**KIRKLEES METROPOLITAN COUNCIL
INVESTMENT & REGENERATION SERVICE**

Reference No:	2024/62/92140/W
Site Address:	16, Town Gate, Upperthong, Holmfirth, HD9 3UX
Description:	Erection of detached garage (within a Conservation Area)
Recommending Officer:	Laura Yeadon

DECISION – CONDITONAL FULL PERMISSION

Officer Report

East Elevation - 1:50

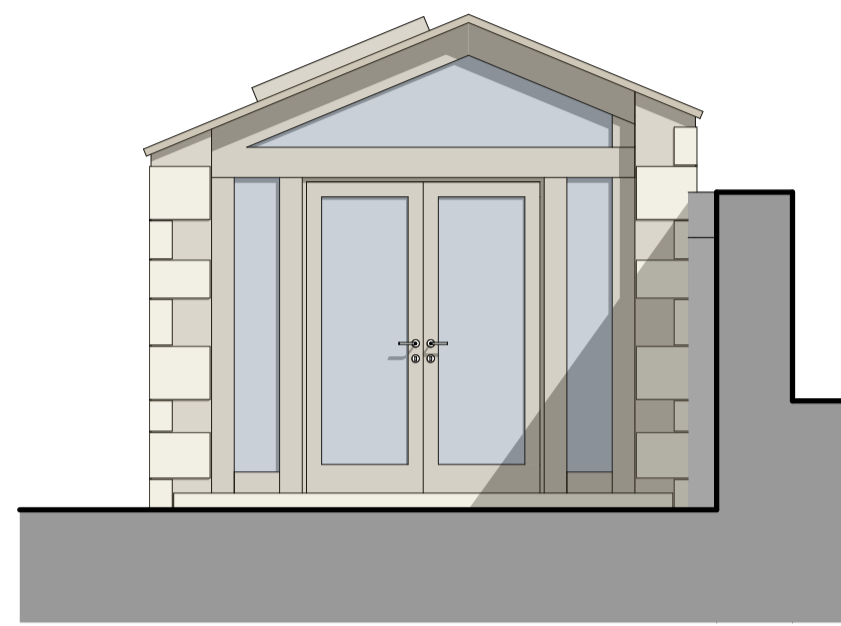
Due to the siting of the garage structure, set so far back from the roadside, it is not considered that it would compete with the host building for significance within the Conservation Area. Informal discussions took place with the Conservation and Design Officer whereby no concerns raised with the proposal in terms of the setting of the Conservation Area. Whilst it is noted that Officer's wish to impose a condition relating to timber openings within the garage structure, given that these were not conditioned on the previous application to extend the property, it would be unreasonable to impose this condition in this case. However, it is considered that the garage door which faces the roadside and public vantage points should be conditioned to be timber with conservation style roof lights within the roof slope.

5. The roof lights shown within the east facing elevation roof slope shall be 'conservation' type and shall be retained thereafter.

South Elevation - 1:50

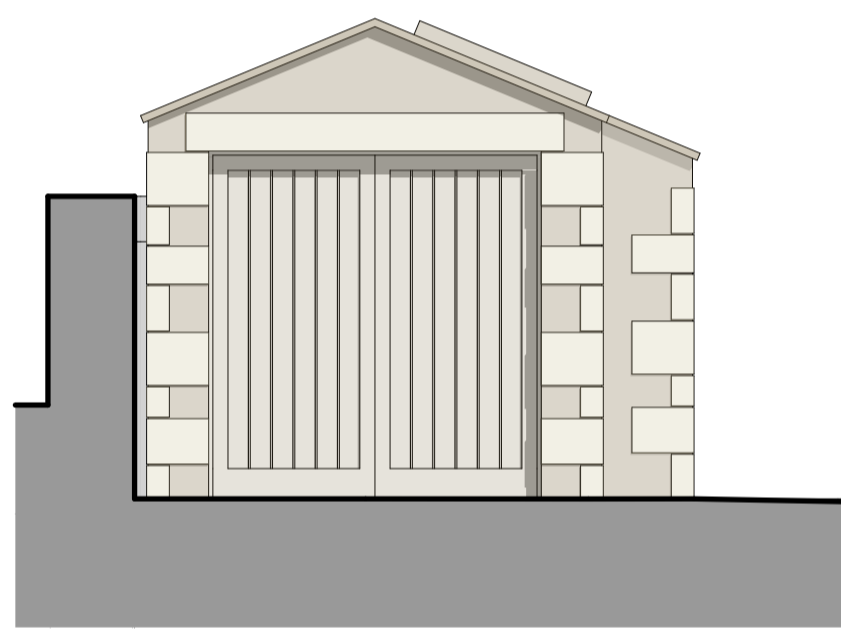
The submitted Heritage Statement states that the building would be a domestic garage and Officers consider that the building would be within domestic curtilage. The openings would be limited to a garage door within the south facing elevation, glazed openings within the north elevation with a window and roof lights within east facing elevation. No windows are proposed within the west elevation which is on the boundary with the adjacent property No. 22 and therefore there are no concerns regarding overlooking to this property. The solid garage door would not cause overlooking, the openings within the south elevation would face the boundary with the fields beyond the curtilage and the side elevation opening would face the garden area of the property. As such, in terms of overlooking, the proposal is acceptable.

4. The garage door within the south elevation shall be constructed from timber and shall be retained as such thereafter.

Proposed Site Plan - 1:100

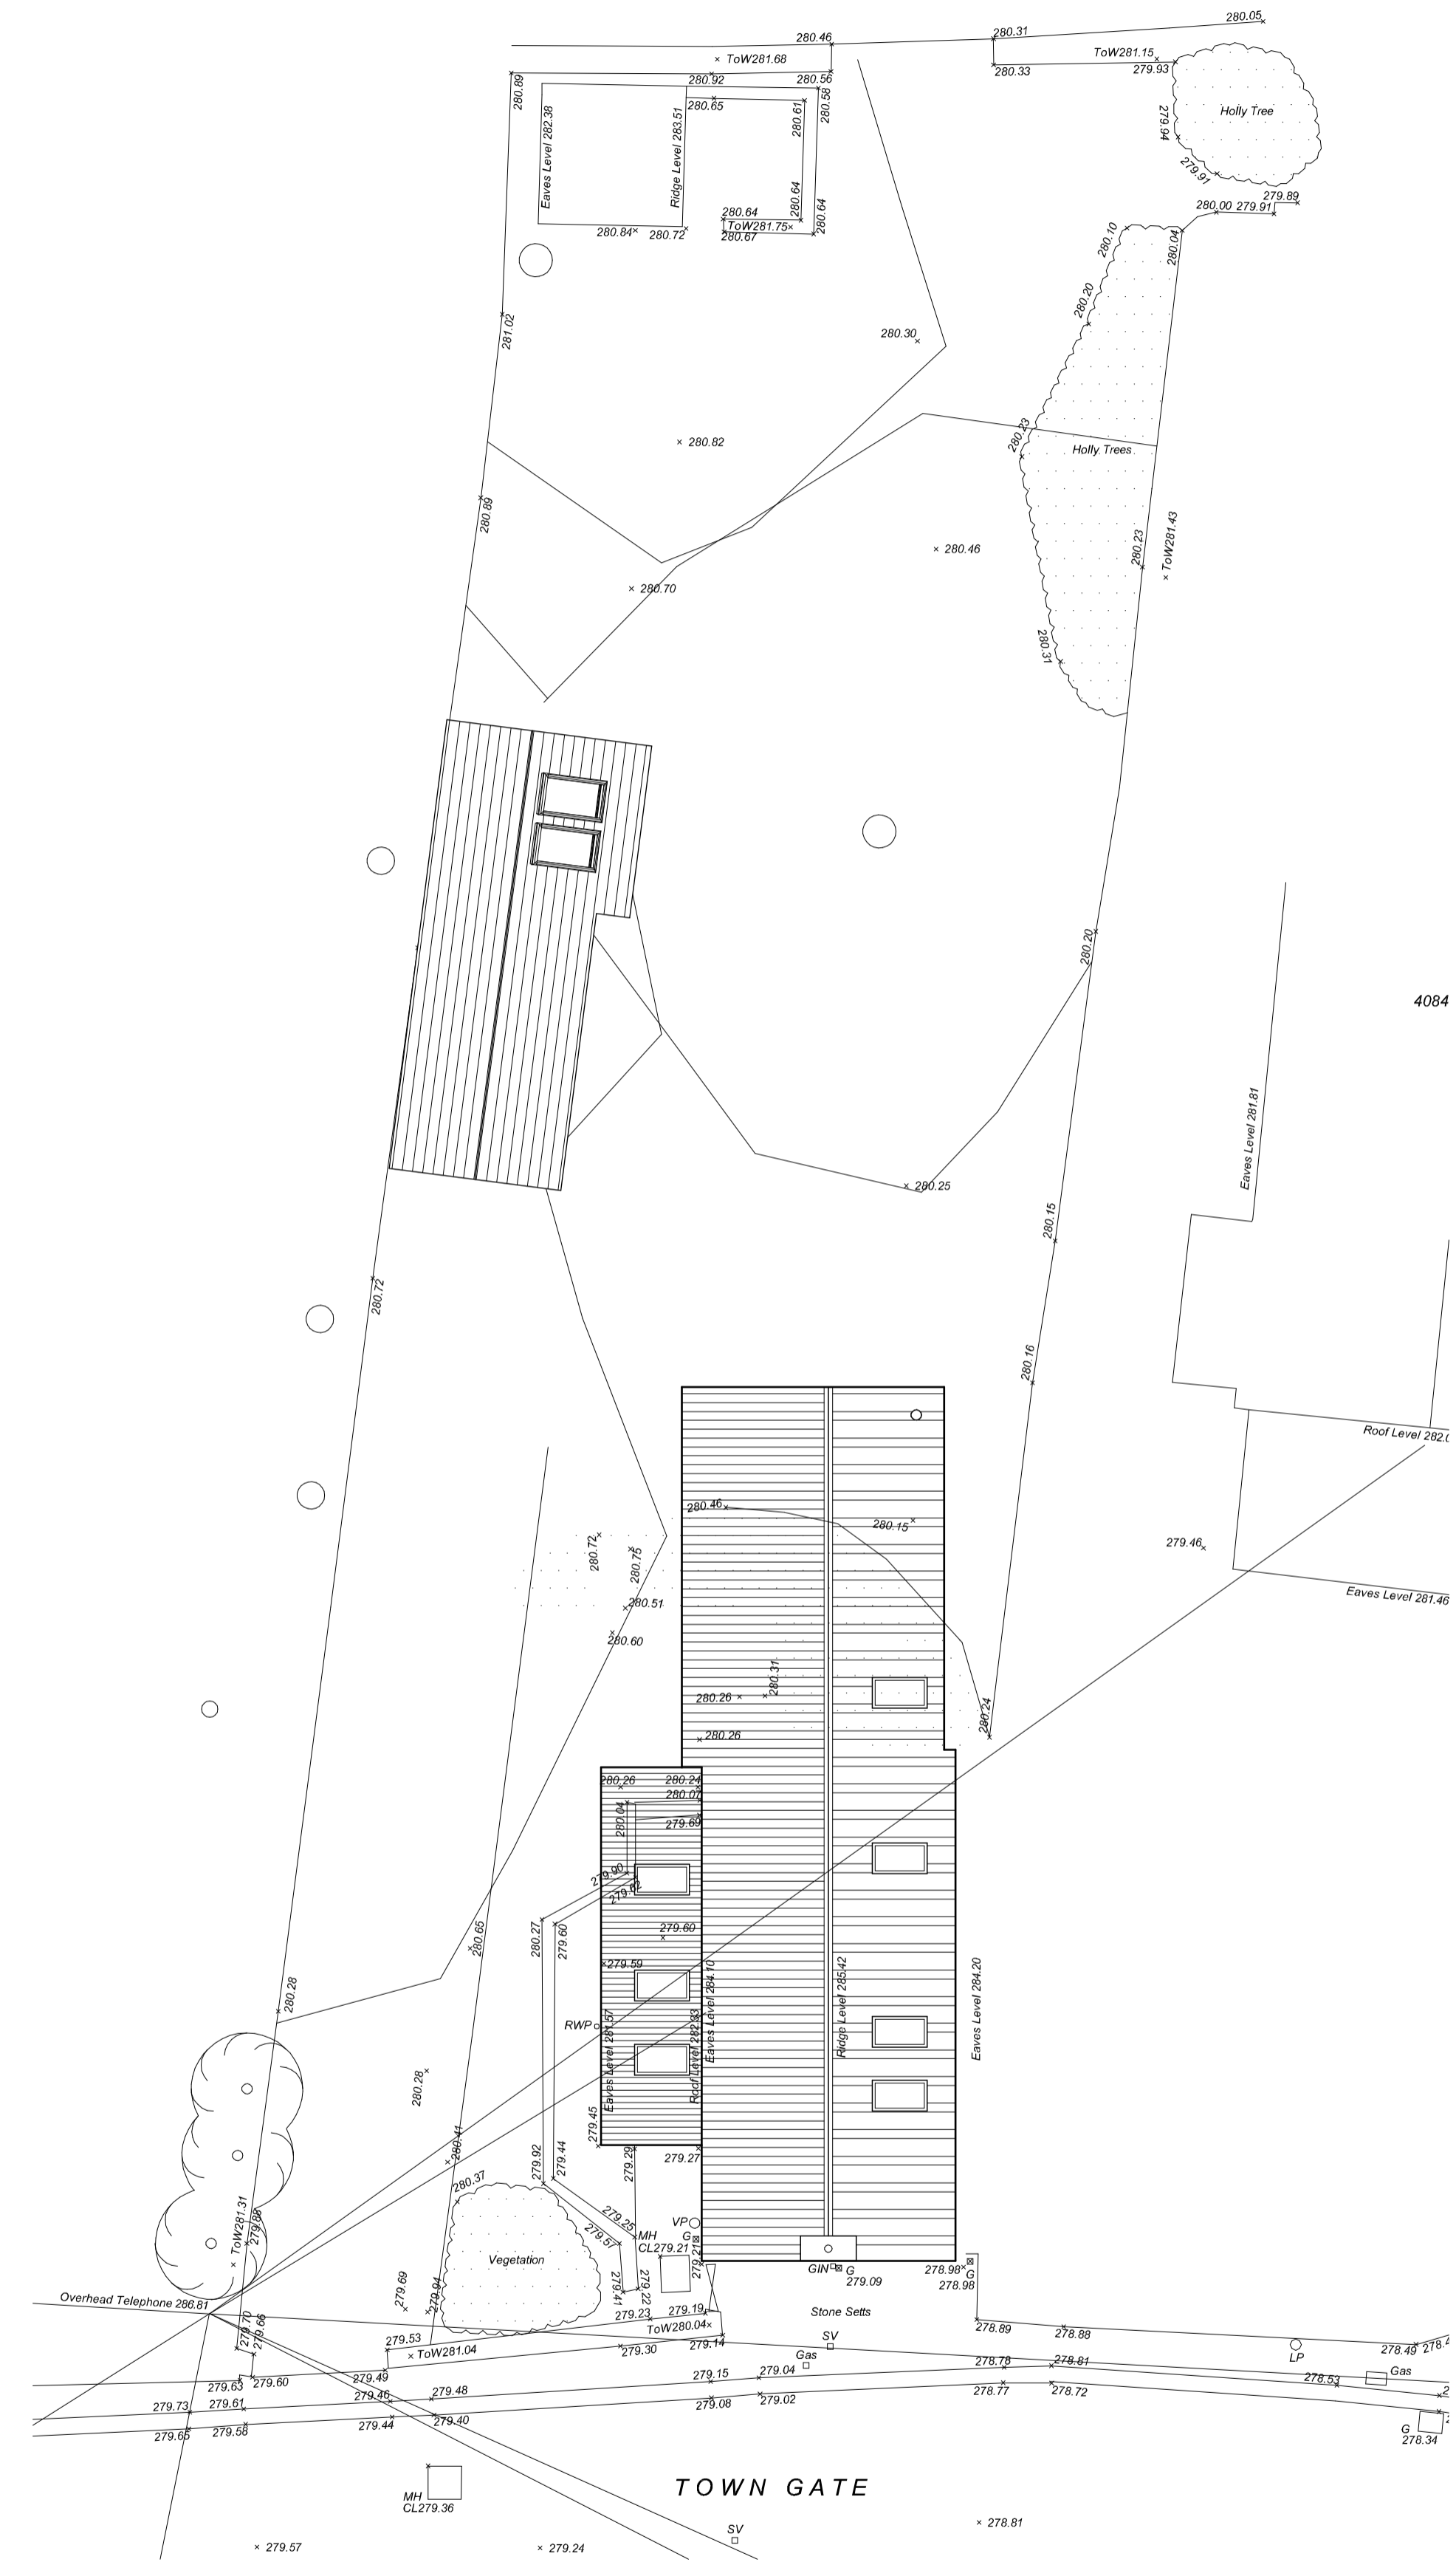
With regards to overshadowing and/or being overbearing, the garage would be located on the boundary with No. 22 and would be set inside a dry stone wall. The submitted details indicate that 0.4 metres of walling would be visible above the boundary wall and fencing boundary treatment and the roof of the garage would slope away from this neighbour. Given the separation distance between the proposed structure and the adjacent property, it is not considered that the proposed works would result in significant harm from overshadowing or by being overbearing.

demonstrate the impact on the trees and that the proposed building is within the RPA of T2 which whilst isn't ideal but may be achievable without any impact to the trees rooting system. As mentioned in the AIA there presence of roots in the proposed footing area which is likely to be minimal but it cannot be confirmed until ground is broken. The AIA suggests trial pits to be dug using hand dig techniques and Officers agree that providing the trial excavations is overseen by the project arboriculturalist. As such a condition has been requested which shall be imposed onto the decision notice.

6. Any excavation within the RPA of T2 is performed using hand tools rather than machinery and that the process is overseen by the project Arboriculturalist and if significant roots are observed then a pile and beam foundation will be utilised to bridge any roots offering them future space to grow.
